**APPLICATION BY HIGHWAYS ENGLAND FOR AN ORDER GRANTING DEVELOPMENT
CONSENT FOR THE PROPOSED M4 JUNCTIONS 3 TO 12 SMART MOTORWAY**

PLANNING INSPECTORATE REFERENCE NO. TR010019

WRITTEN EVIDENCE ON HIGHWAY MATTERS

**ON BEHALF OF BUCKINGHAMSHIRE COUNTY COUNCIL
AS HIGHWAY AUTHORITY**

Drawing title
SIDE ROAD PLAN & PROFILE
REGULATION 4(2) (e)
SHEET 3 OF 13
MARSH LANE

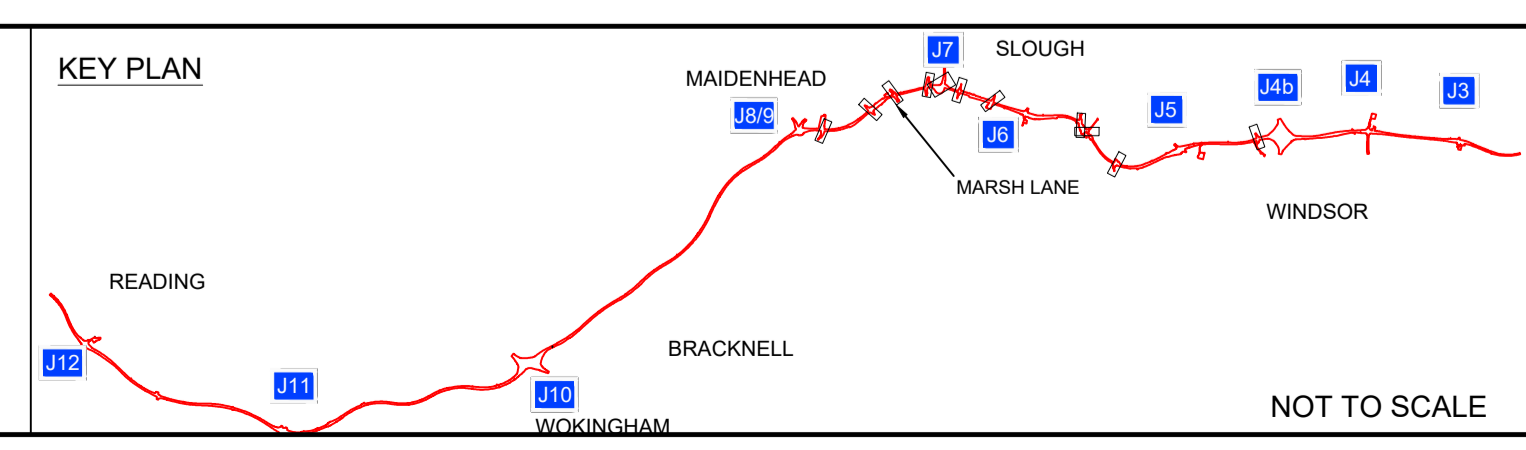
5.6 Marsh Lane will be shut whilst a new bridge is constructed on-line between November 2018 and December 2019. The potential diversion route is via Lake End Road/A4 Bath Road and involves a 10km detour. Lake End Road and its junction with the A4 Bath Road will experience increased traffic as part of the planned online development of Marsh Lane over a 13 month period. The impact of this diversion route, particularly on the junction of Lake End Road and the A4 Bath Road has not been assessed and Buckinghamshire County Council cannot confirm that it will not be severe.

Drawing title  
SIDE ROAD PLAN & PROFILE  
REGULATION 4(2) (e)  
SHEET 4 OF 13  
LAKE END ROAD

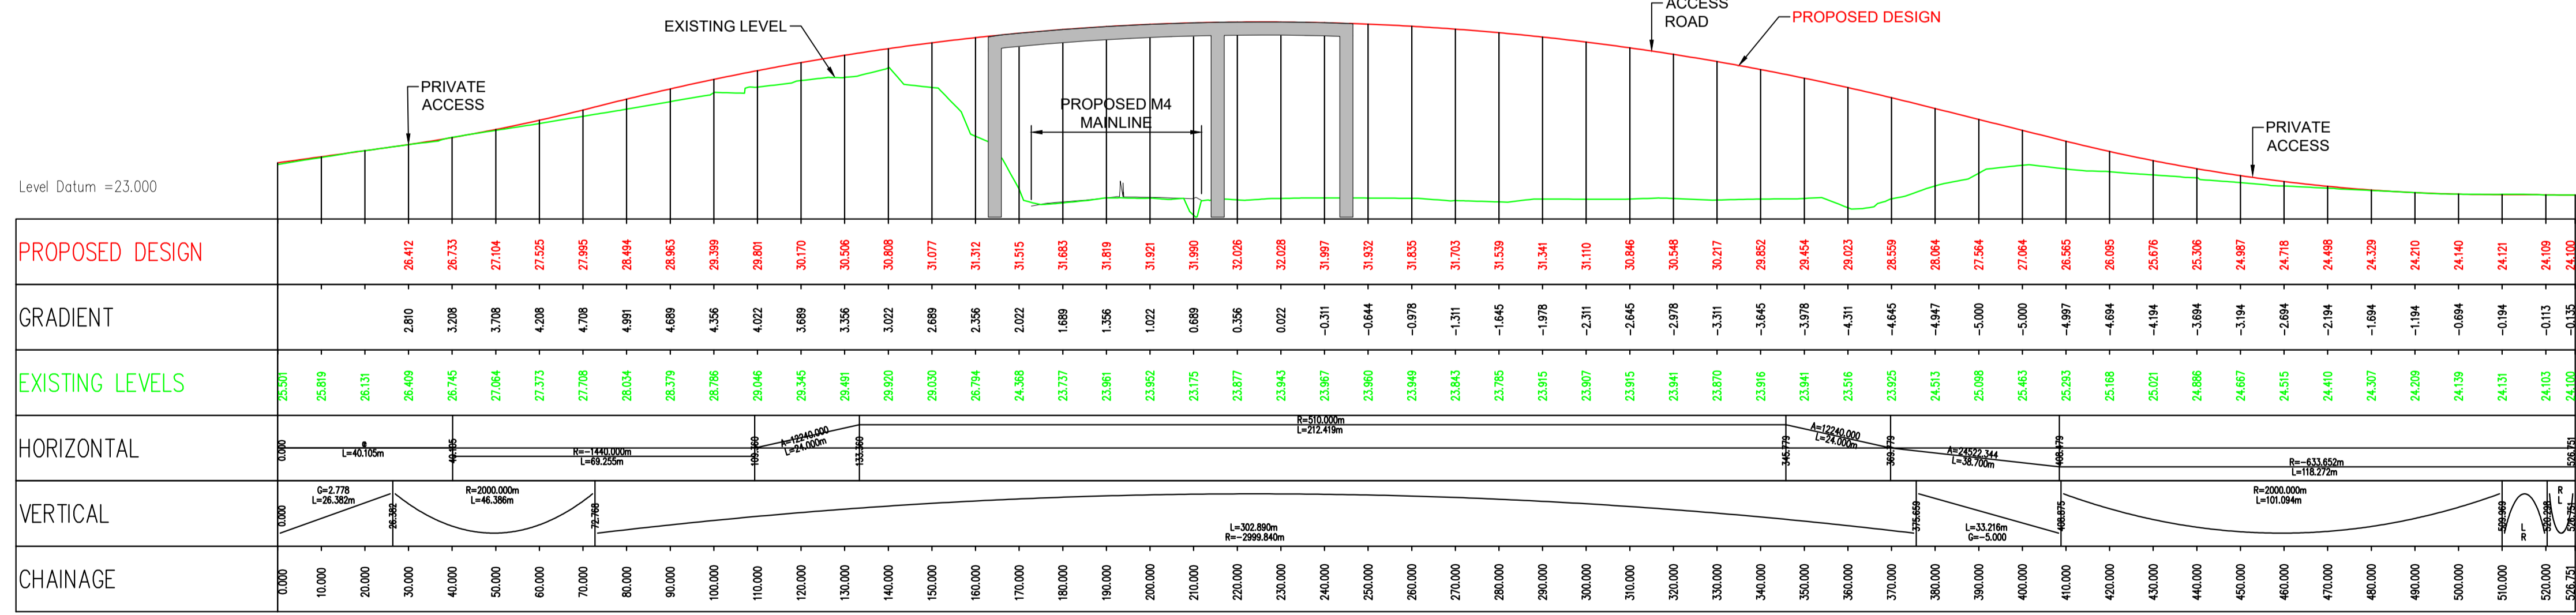
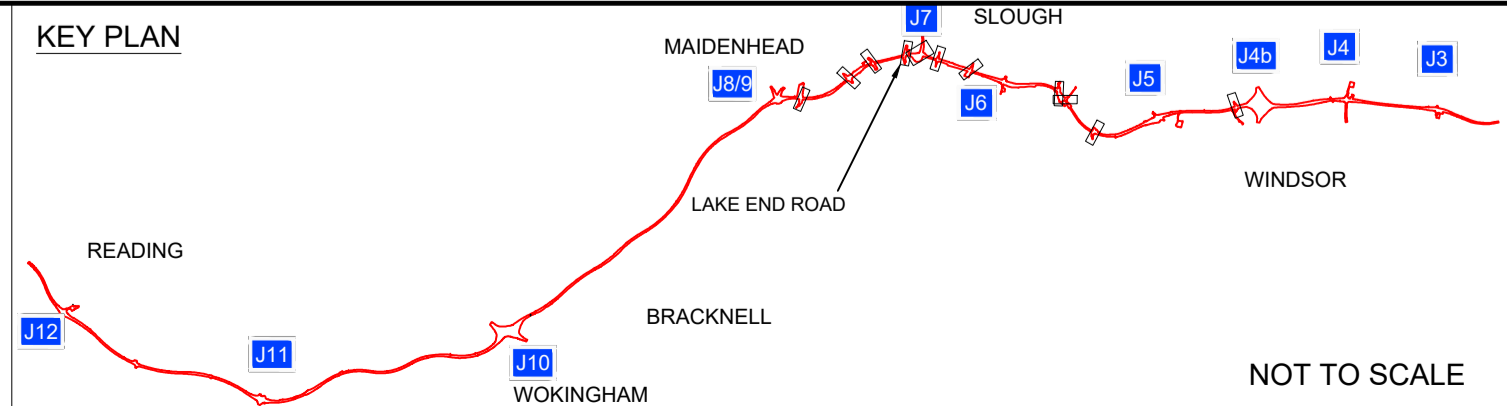
5.5 Lake End Road is to be built off-line, following representations made during the formal consultation. The HE have agreed in the draft SoCG that works to Lake End Road and Marsh lane will not be undertaken during the same period. Lake End Road bridge is to be constructed first, followed by Marsh Lane bridge as illustrated in the construction programme in Appendix 4.1 of the ES.
